Consultation response

A/54/20/HH

Ariston, Water Lane Angmering BN16 4EJ

Proposed conversion and extension to existing garage into ancillary accommodation, new driveway to front of property.

HAPA ARCHITECTS			
Job Name			
Ariston, Water Lane, Angmering, Littlehampton			
Status	PLANNING	Drawing Type	PROPOSED SITE PLAN/ BLOCK AND PROPOSED GARAGE CONVERSION PLAN AND ELEVATIONS
Date	APRIL '20	Scale	1:50, 100 & 500 @ A1
Job Ref			WL_101
Drawing Number			L-200a

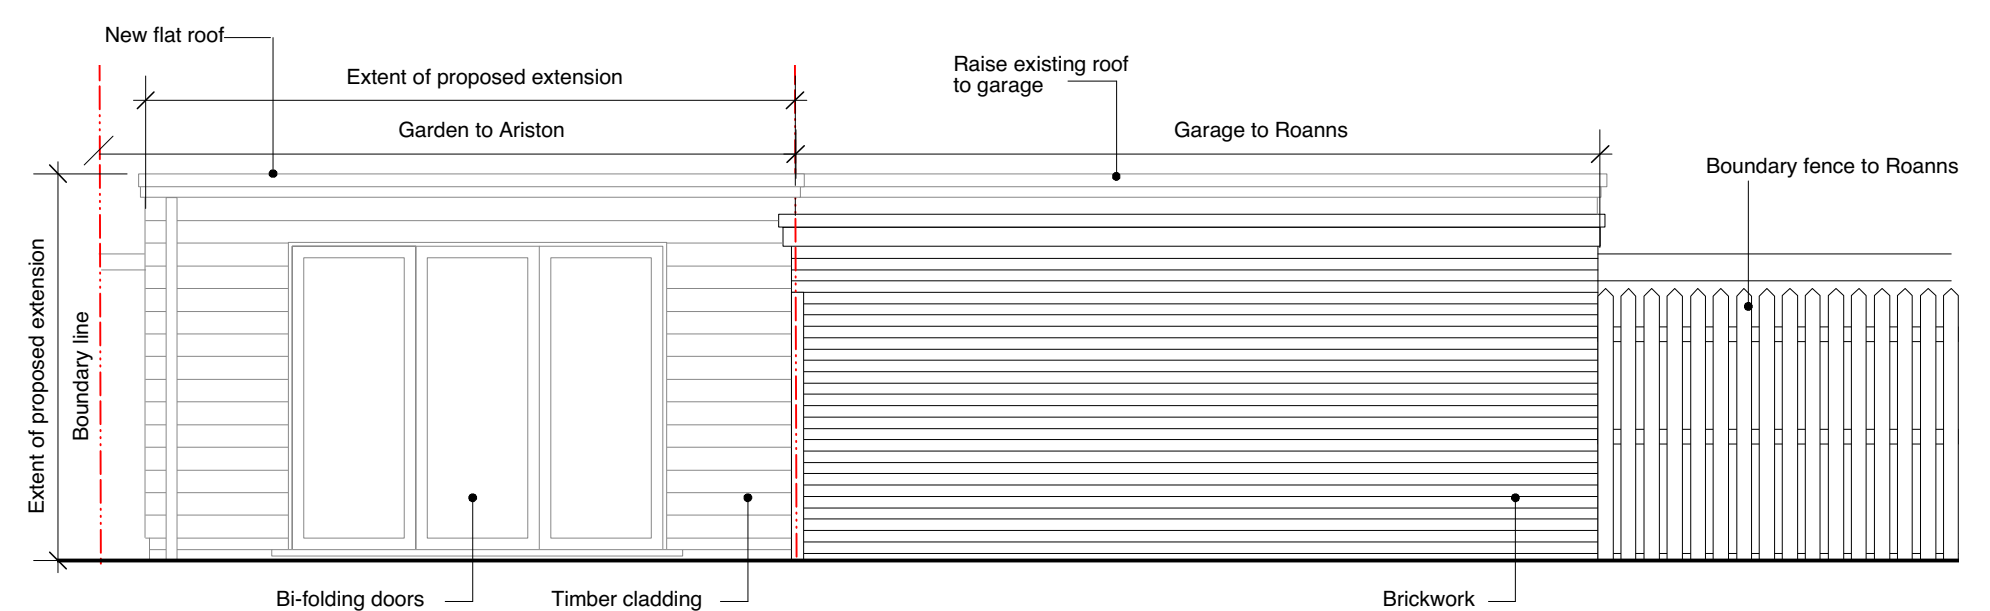
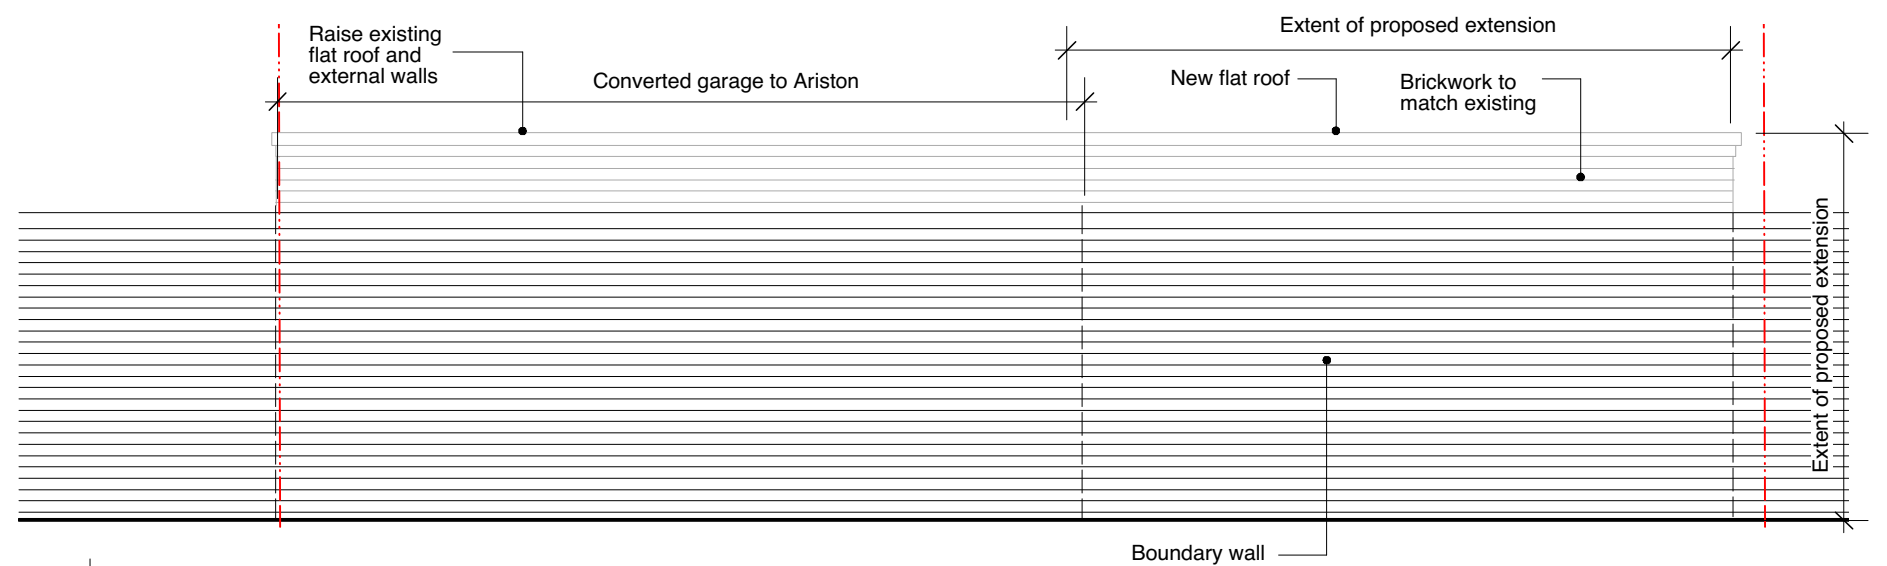
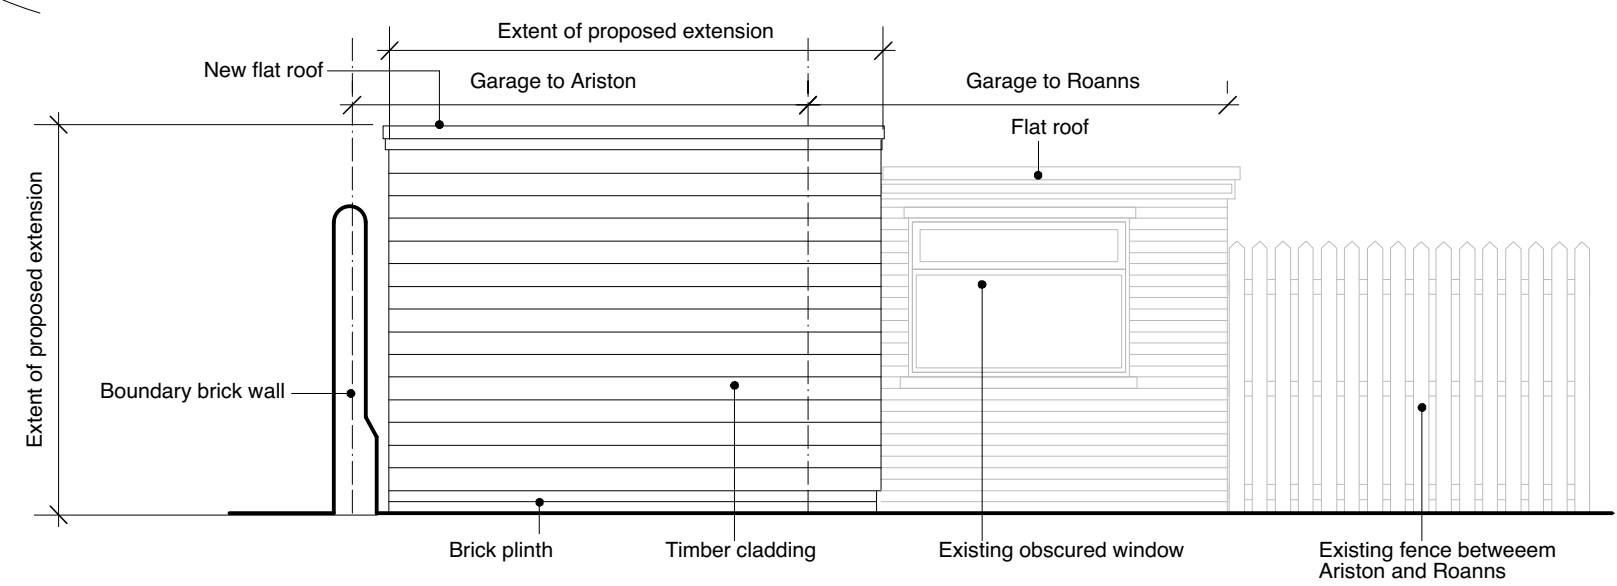
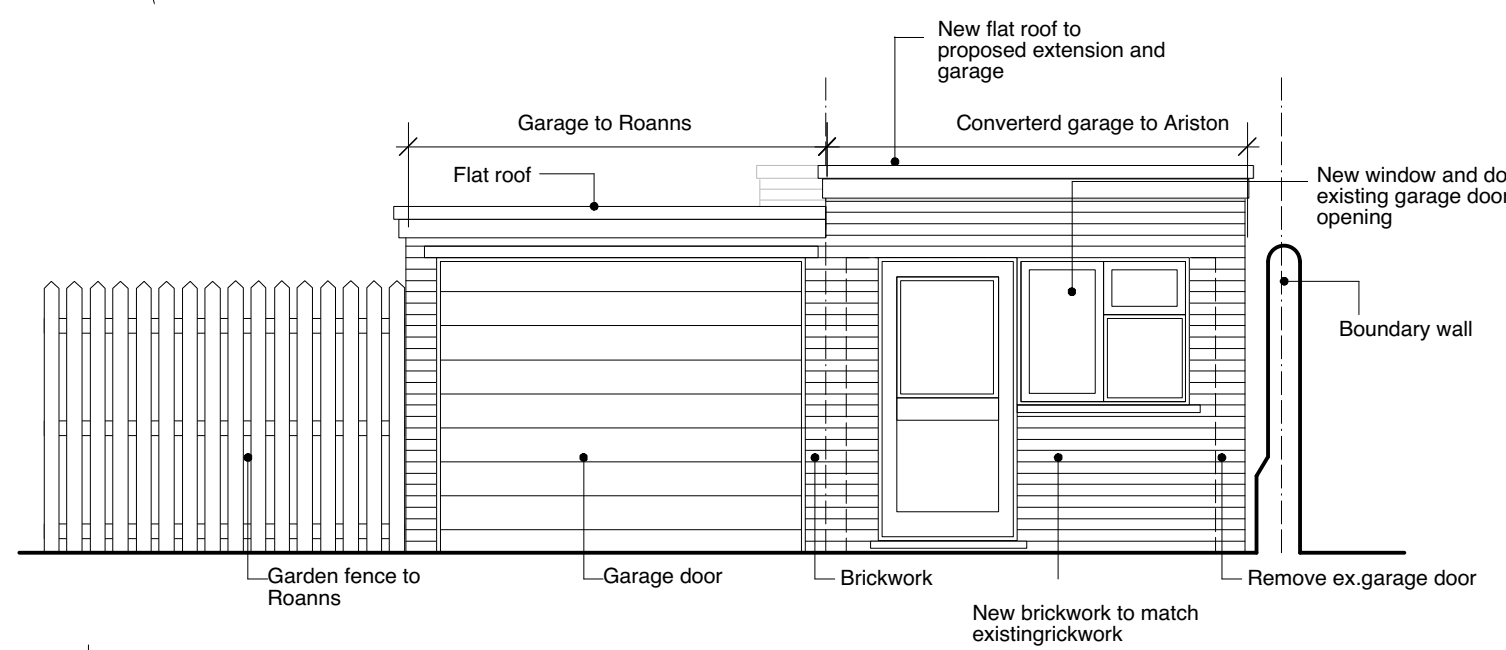
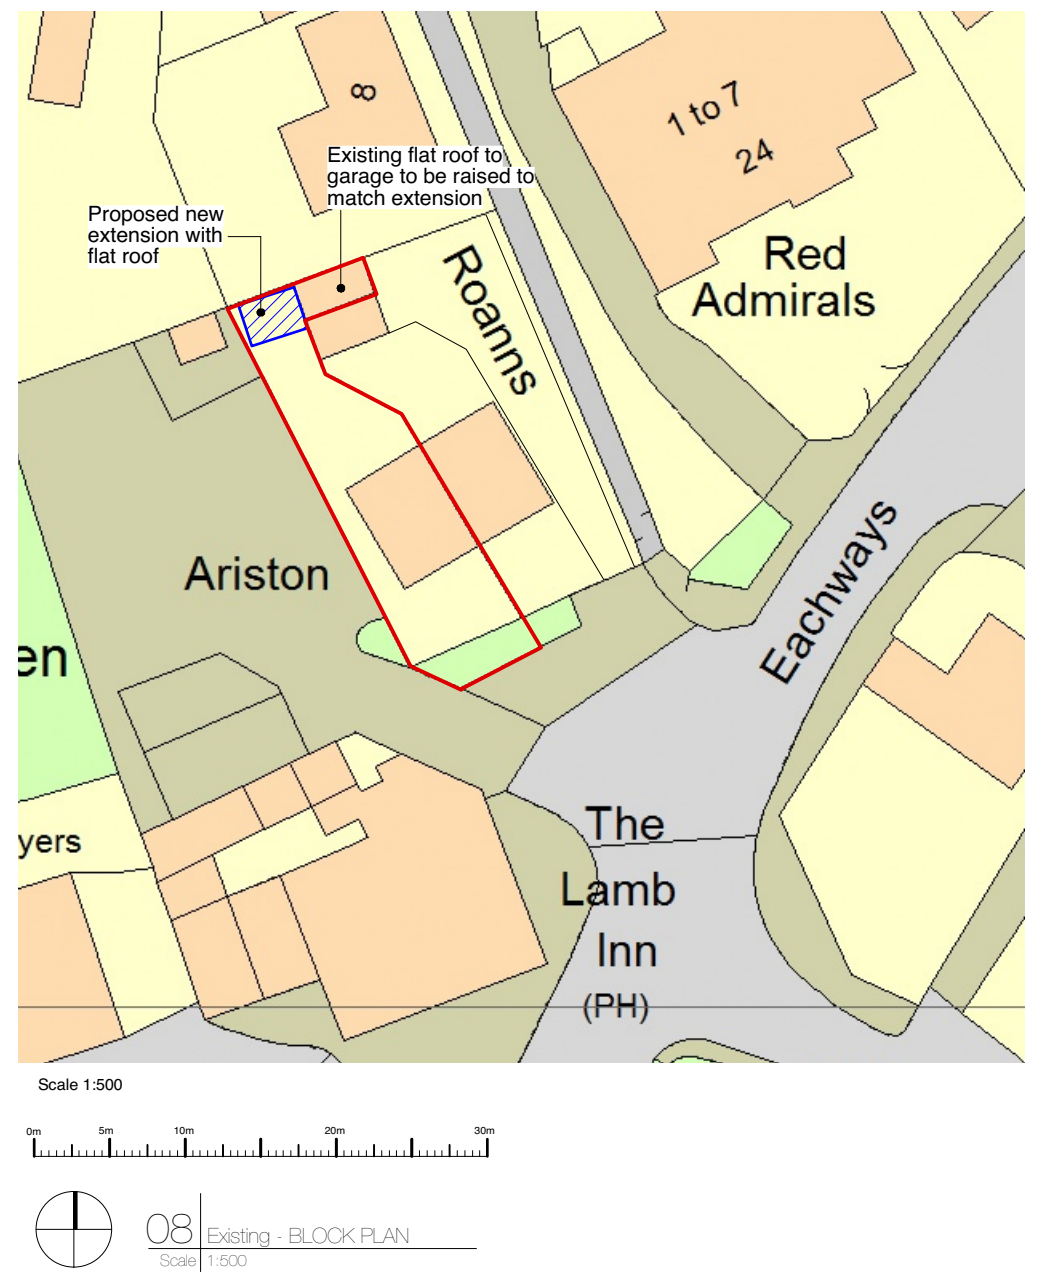
The proposed front driveway will be provided on an area of front garden space which is currently laid to grass. It would appear to be of a similar level to the neighbouring tarmac surface and will retain the low wall to the front and side boundary. A new retaining wall is required which should use materials similar to that already present.

The existing front wall is of a height which would mean that any vehicle would be clearly seen when parked. However, it is noted that there is already parking to the front of the site. As a consequence, the additional of one parking space will not cause further harm to the assets concerned.

The extension to the garage will provide for additional accommodation for the property and would be located so as to not be clearly visible from the public domain. It is also of a simple style so as to not cause harm to the heritage assets. The use of timber cladding is considered to be acceptable, subject to its treatment.
